Application for a Non-Material Amendment Following a Grant of Planning Permission

Creation of a front dormer to the first floor as an infill between two existing dormers, with a central single-pane window and sun pipe to its roof, installation of sun pipe to the existing front porch roof and minor internal alterations to the ground and first floors.

22/02059/HOU

Amendment of the centrally positioned single pane window, as was approved, to a double pane window.

Drawing No  
**P-001.03-A**

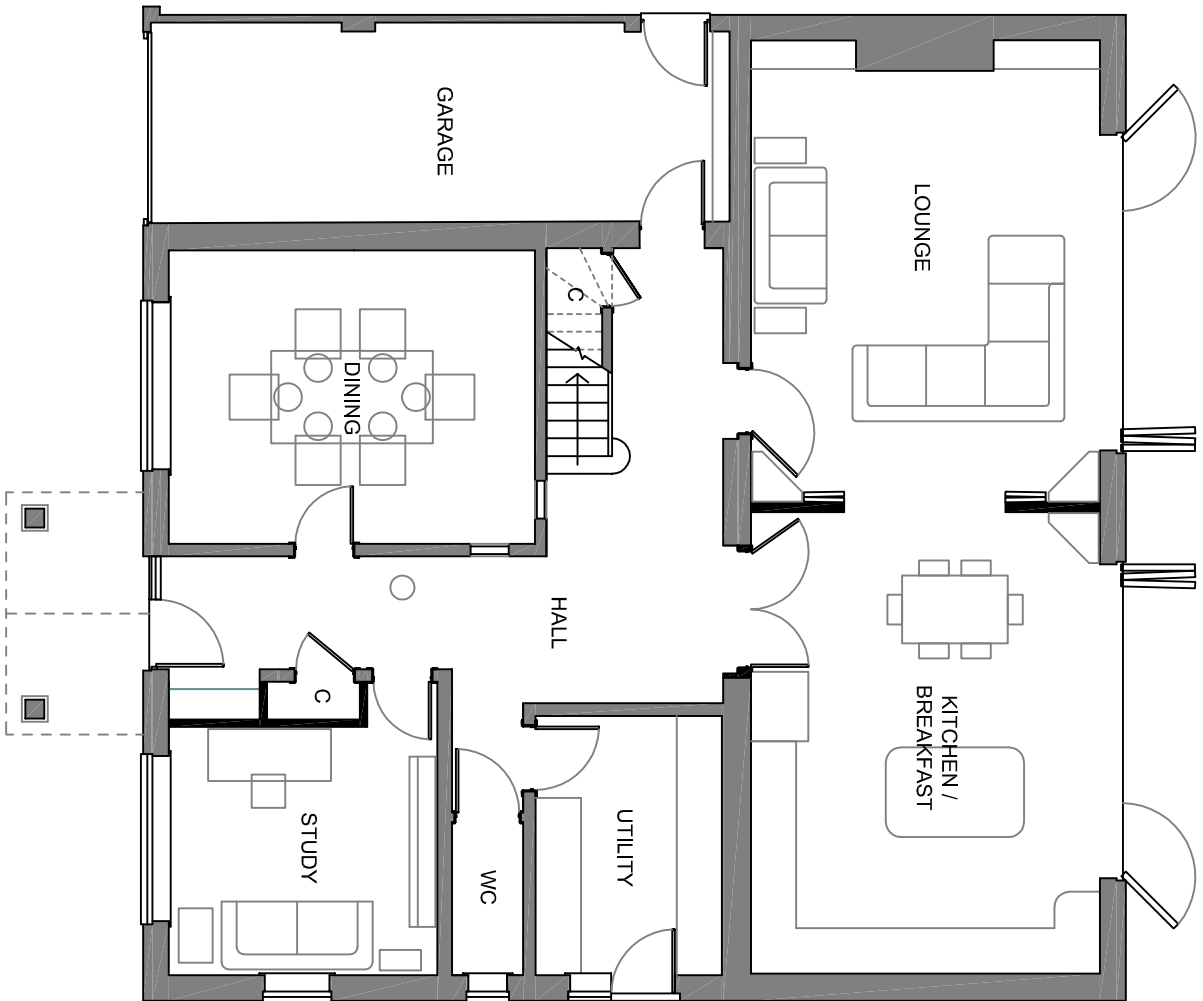
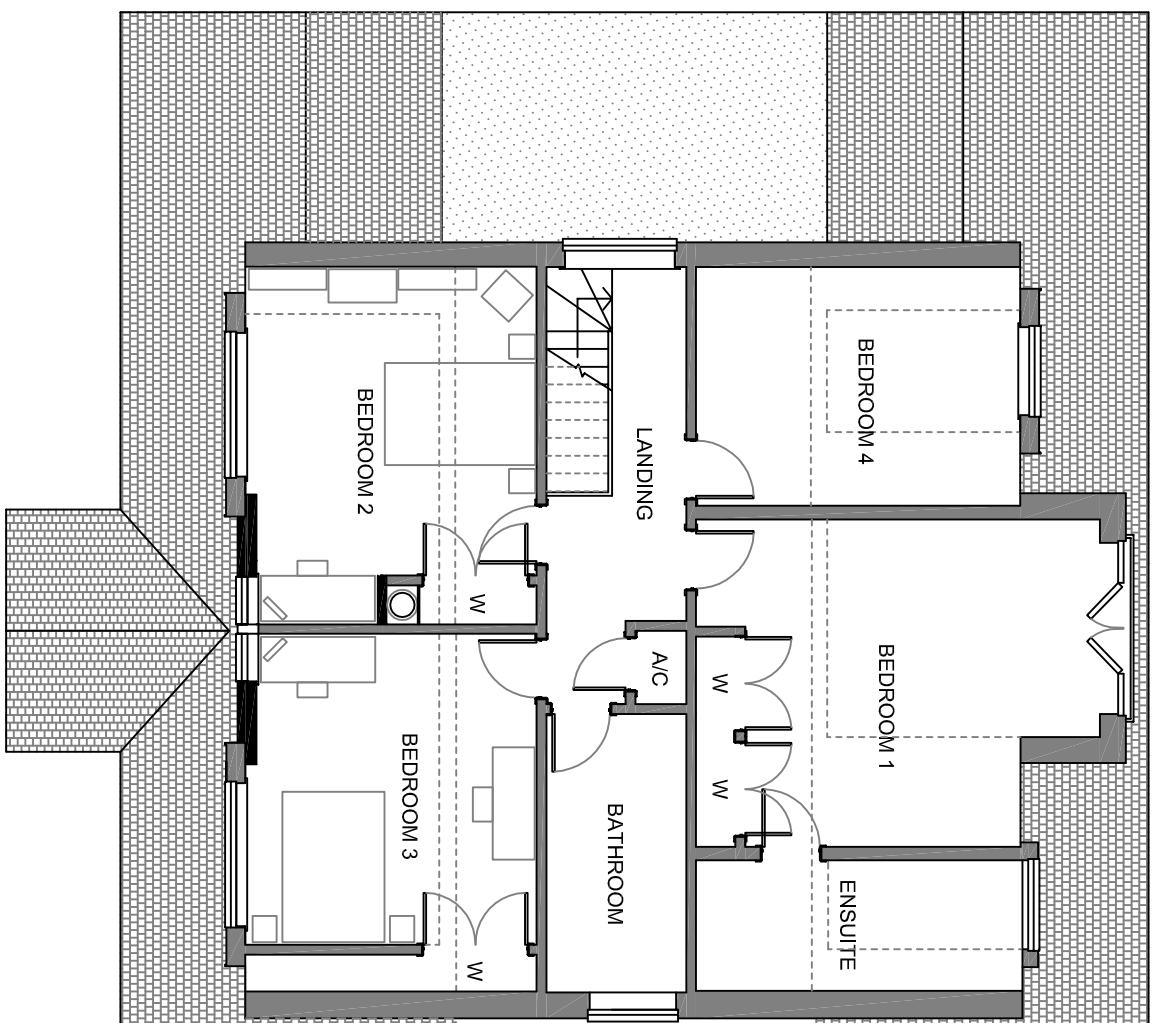
The amendment allows for more much needed daylight into both front-facing (northerly) bedrooms rather than just one, whilst also meaning less internal wall reconfiguration and disturbance in general in respect of the overall build programme. This amendment is considered to result in more harmony between ground and first floor fenestrations in terms of widths, positioning and formation. The materials and style will again match the existing, and the previous arguments cited at the time of the original and subsequently approved application pertaining to surrounding privacy still apply: There are no dwellings opposite the subject property - only a car park ("Charles Close") - which is itself set some distance beyond, and there is a large amount of natural shielding of the subject property from the street and indeed along both sides of the road by a line of mature Horse Chestnut trees.
